MEMORANDUM

SUBJECT: MS-20-002 – Dwire Storage Yard Filing No. 1
First Submittal

LSC Responses (7-11-2020): See below.

## GRADING AND EROSION CONTROL PLAN

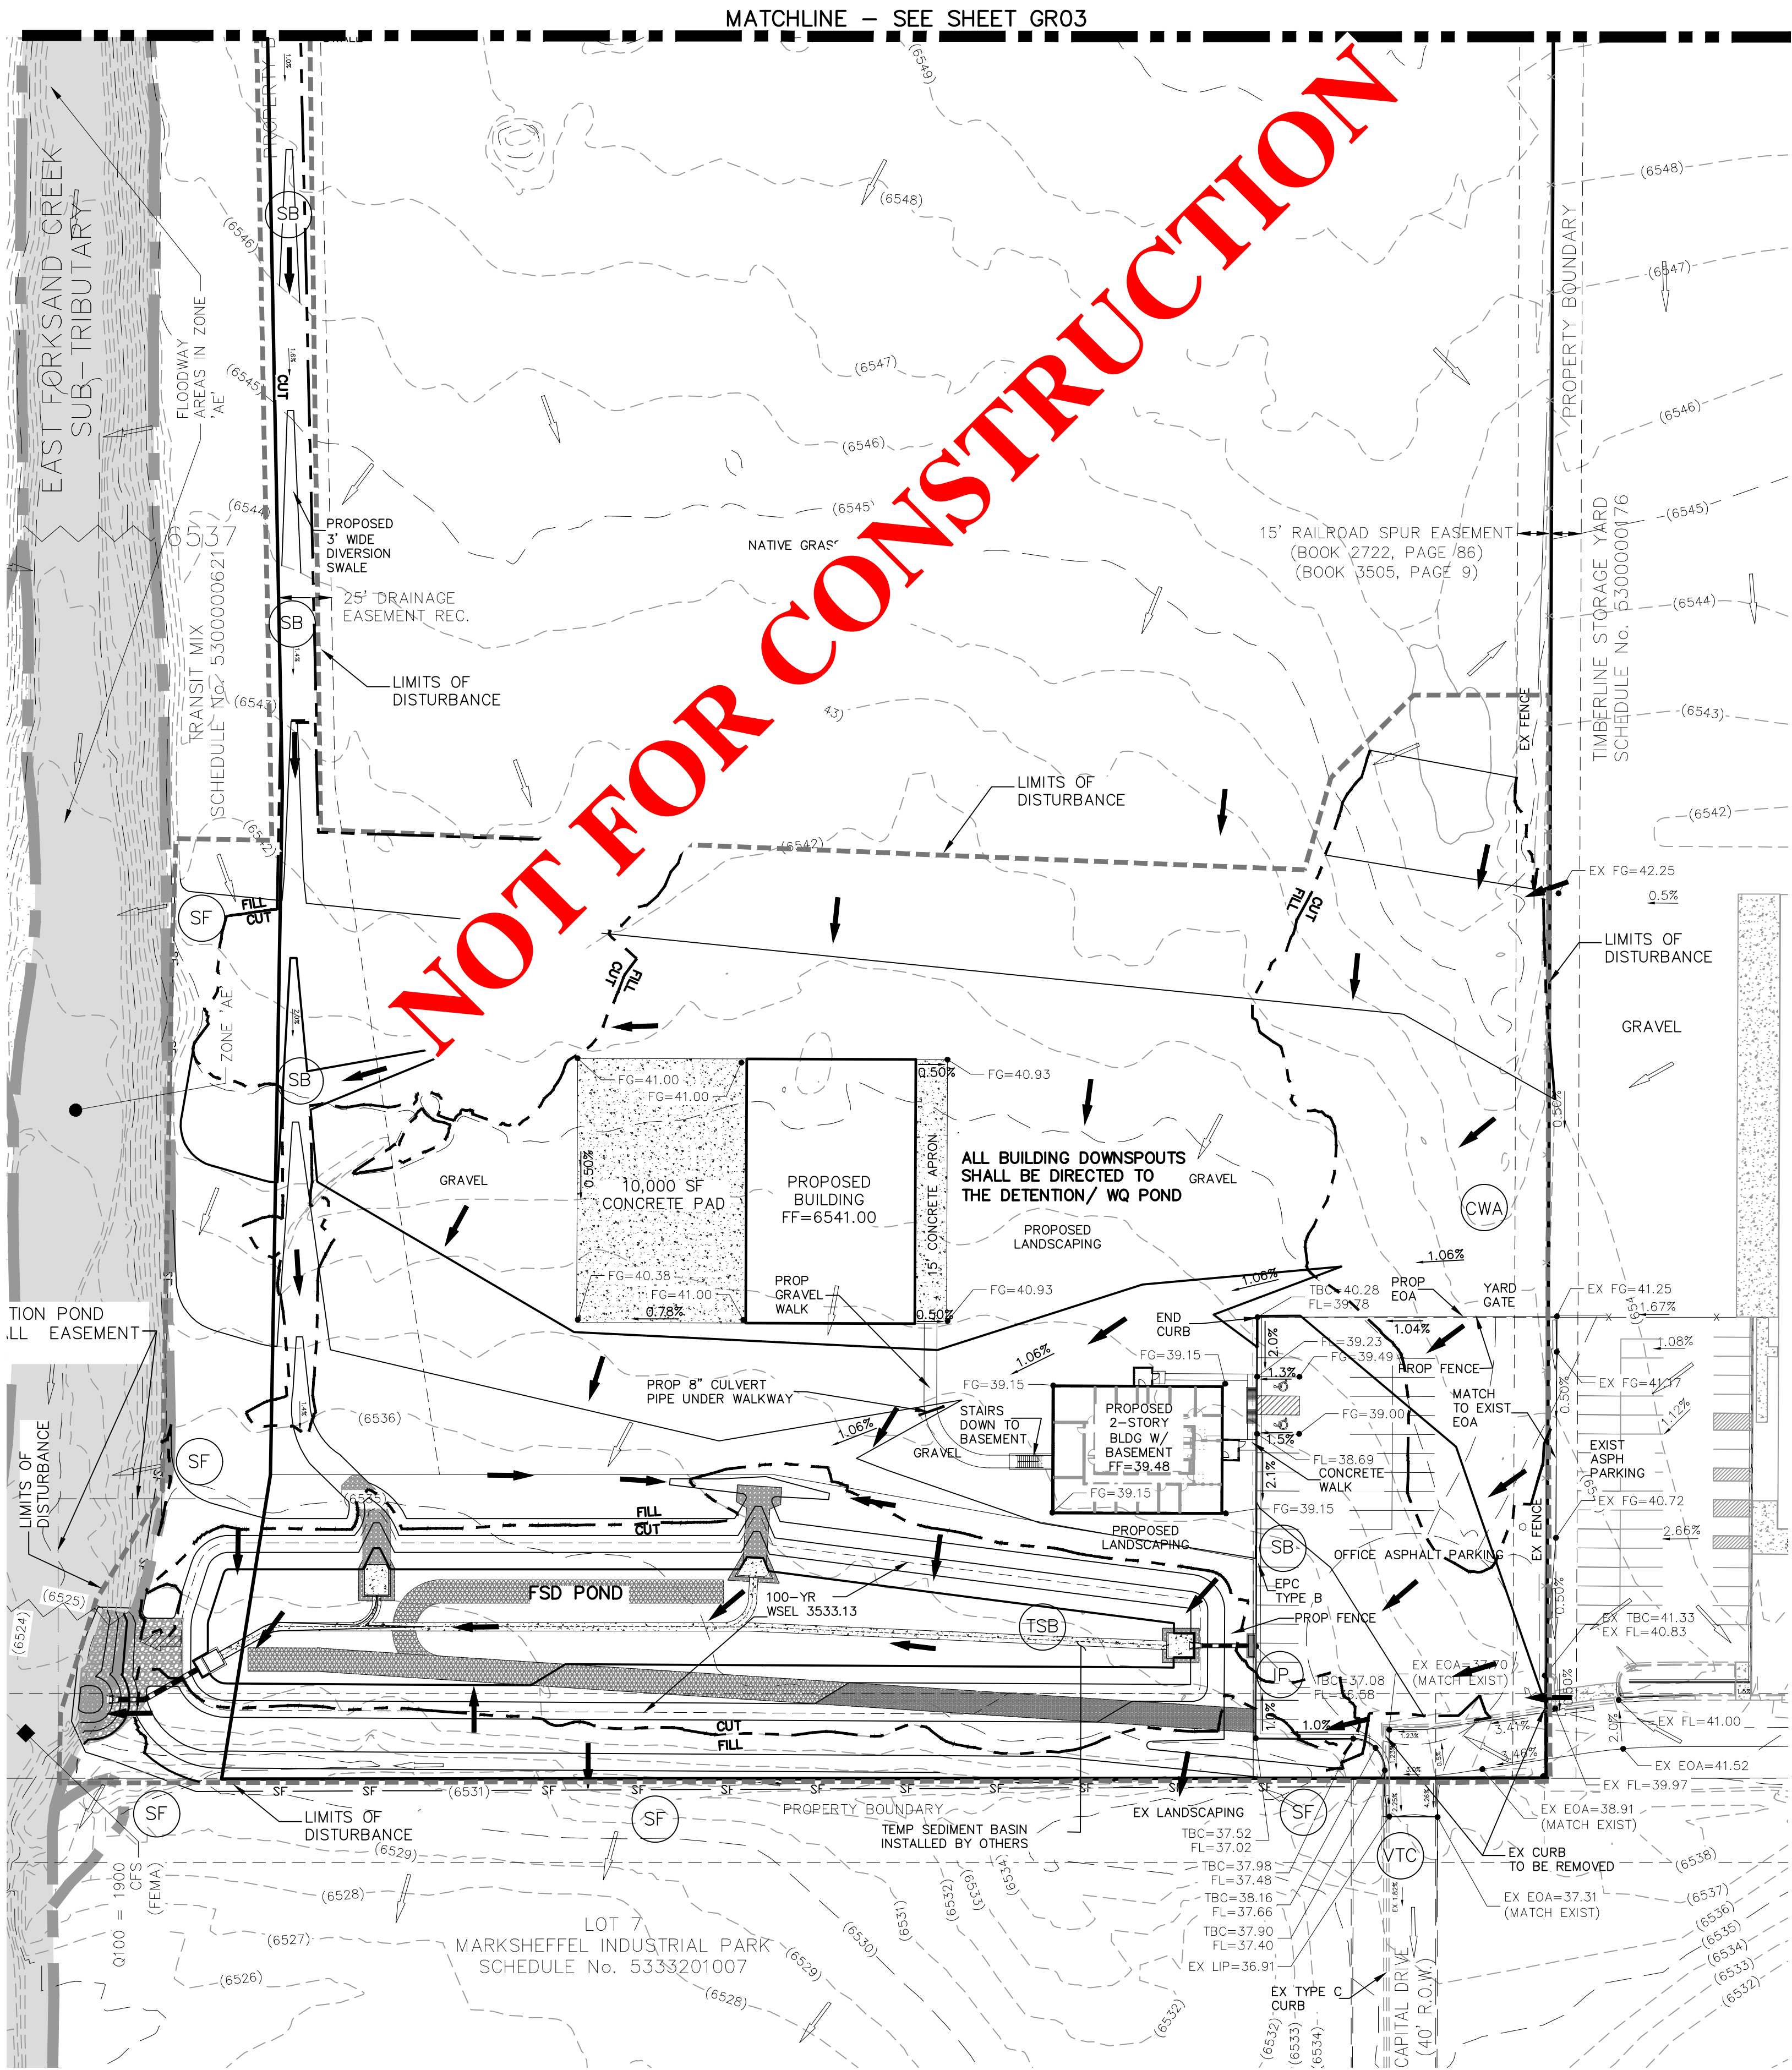
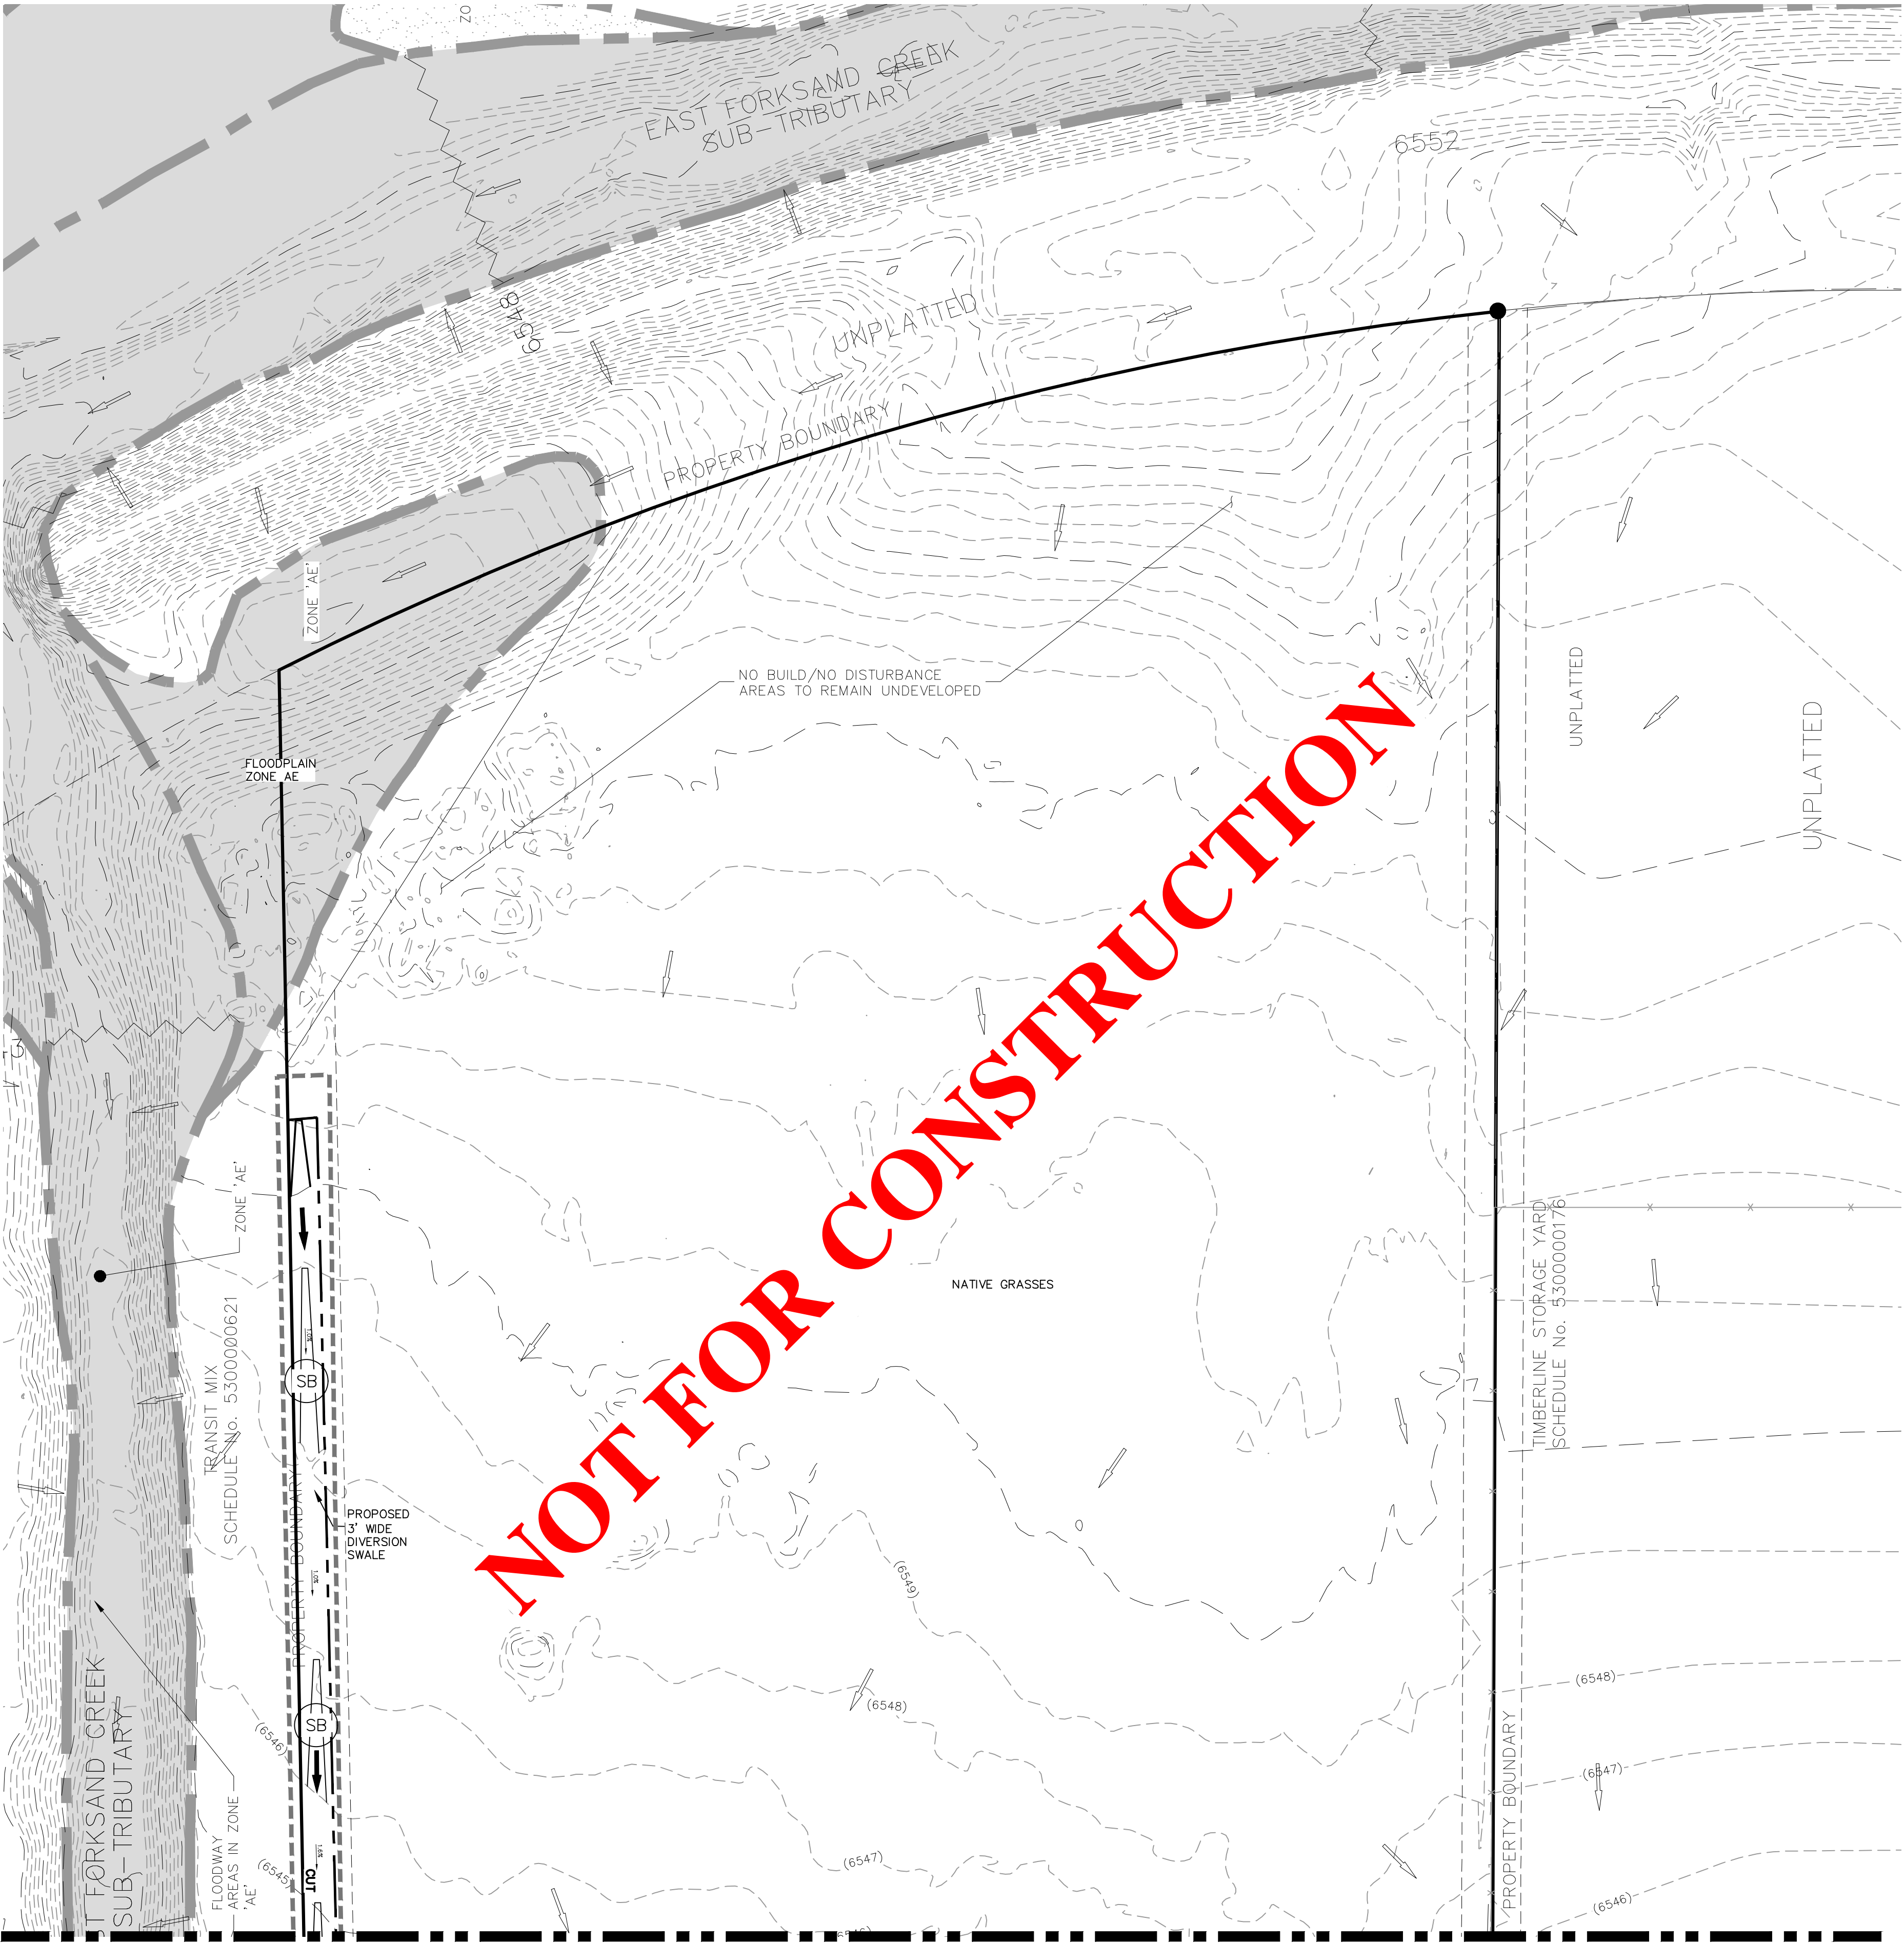
4. Show and label the offsite easement to the west for detention pond construction and outfall.
5. Show and label all existing and proposed easements including the 10-foot drainage easement on the property to the south.

6. Note: the silt fence (or other BMPs as revised) shown on the property to the south requires permission from that owner to install. Some type of channel erosion and sediment control is (straw checks/sediment control logs/etc.) should be provided in the revised flowline. Provide documentation from the adjacent property owner that the change in drainage pattern (runoff from Dwire property, being pushed from the existing swale onto their property) is acceptable to them. Label the side slope and flowline grades of this adjusted swale. Ensure that no utilities are impacted.
